KIRKLEES METROPOLITAN COUNCIL INVESTMENT & REGENERATION SERVICE

DELEGATED DECISION TO DETERMINE APPLICATIONS FOR LISTED BUILDING CONSENT

Reference No:	2023/65/90043/W
Site Address:	The Farmhouse, Carr Farm, Uppergate, Hepworth, Holmfirth, HD9 1TG
Description:	Listed Building Consent for erection of single storey extension with associated works and solar panels (Listed Building within a Conservation Area)
Recommending Officer:	William Simcock

Officer Report – The Farmhouse, Carr Farm, Hepworth 2023/90043 – Listed Building Consent

FRONT ELEVATION - EXISTING
SCALE 1:50 ON A1

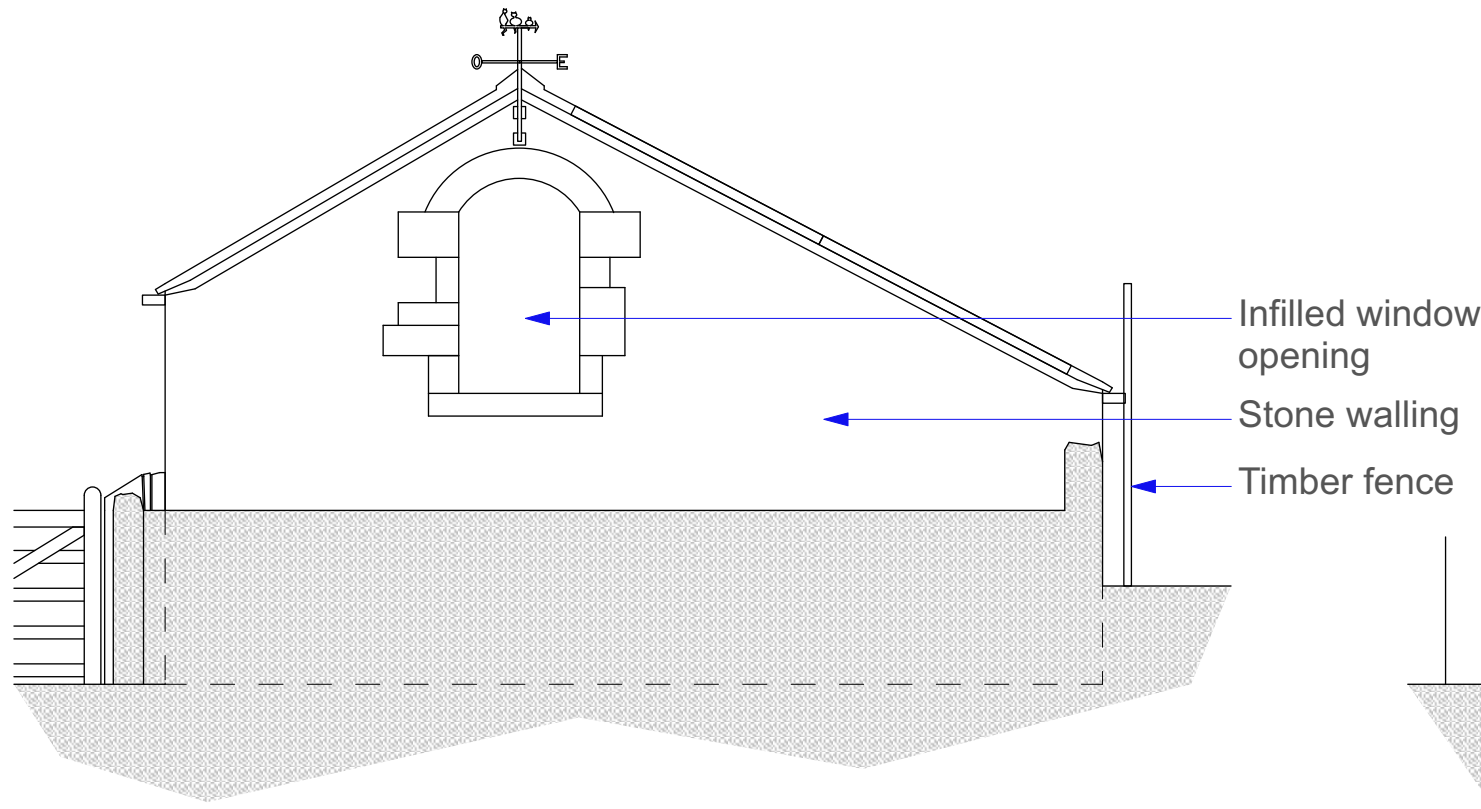
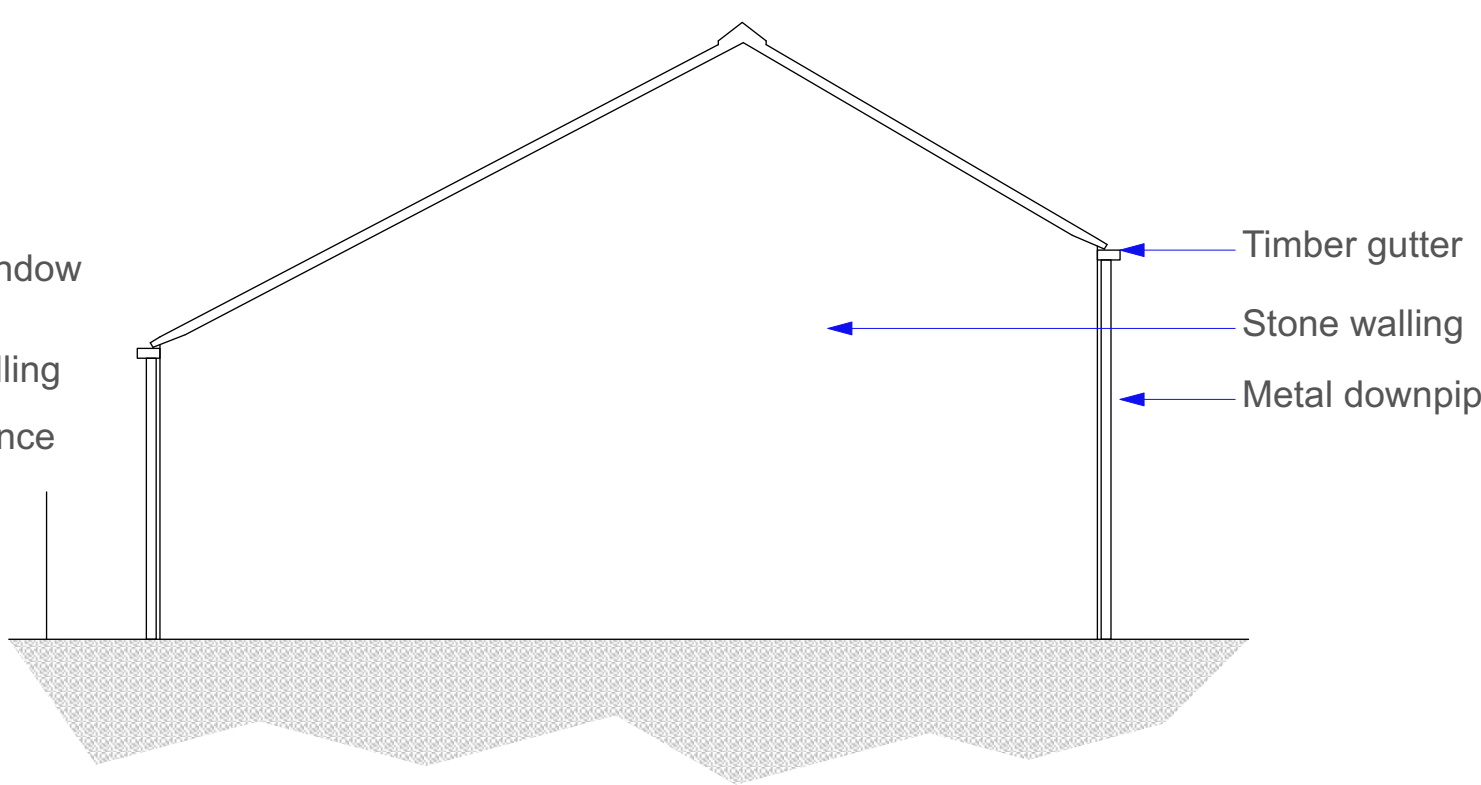
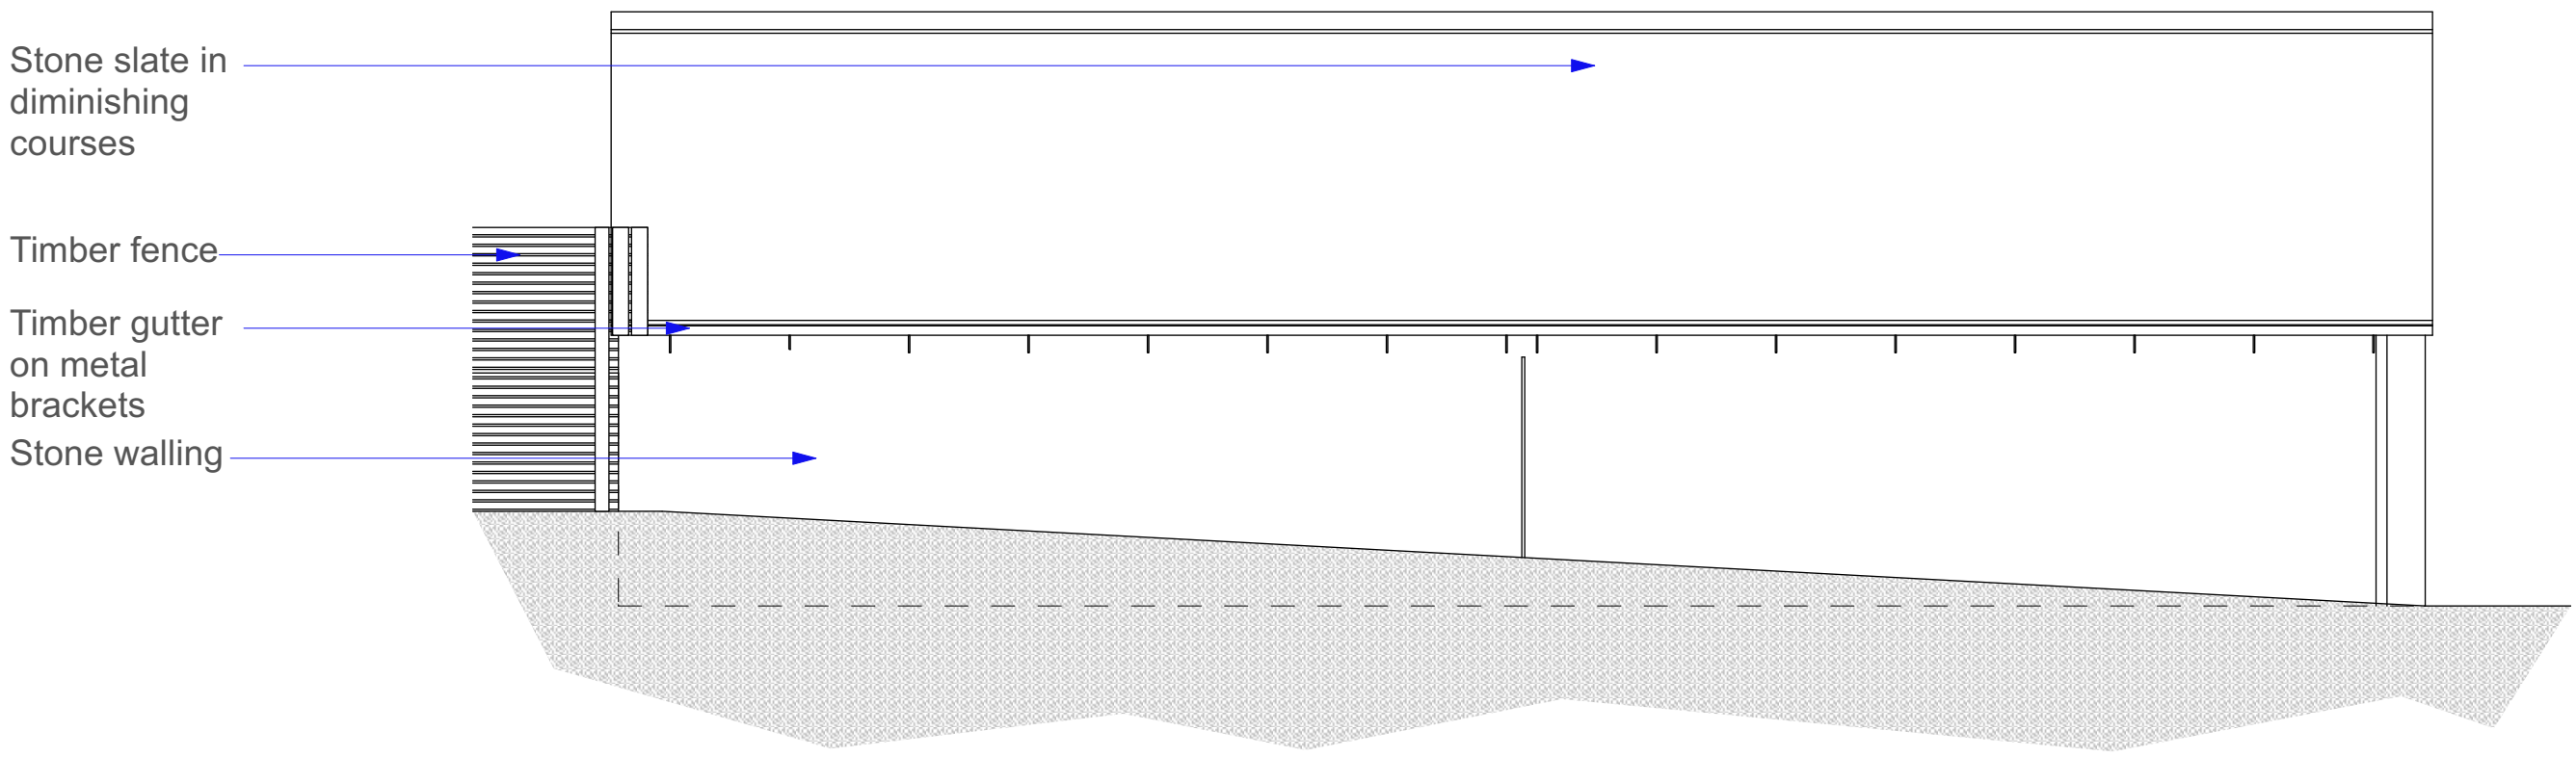
KC Conservation & Design – Originally requested the solar panels to be reduced in numbers and moved towards the centre of the garage roof. Final comments, made informally and received 11th December, are that the proposal can be accepted without any further alteration. Earlier comments dated 30th November provide a full list of recommended conditions for the works to the Farmhouse.

It is noted that the outbuilding is not expressly Listed although it is Listed by association, by reason of being an original curtilage building. The solar panels would be a modern feature but they would be a reversible change and it is considered that the impact on the significance of the Listed Building would be minimal.
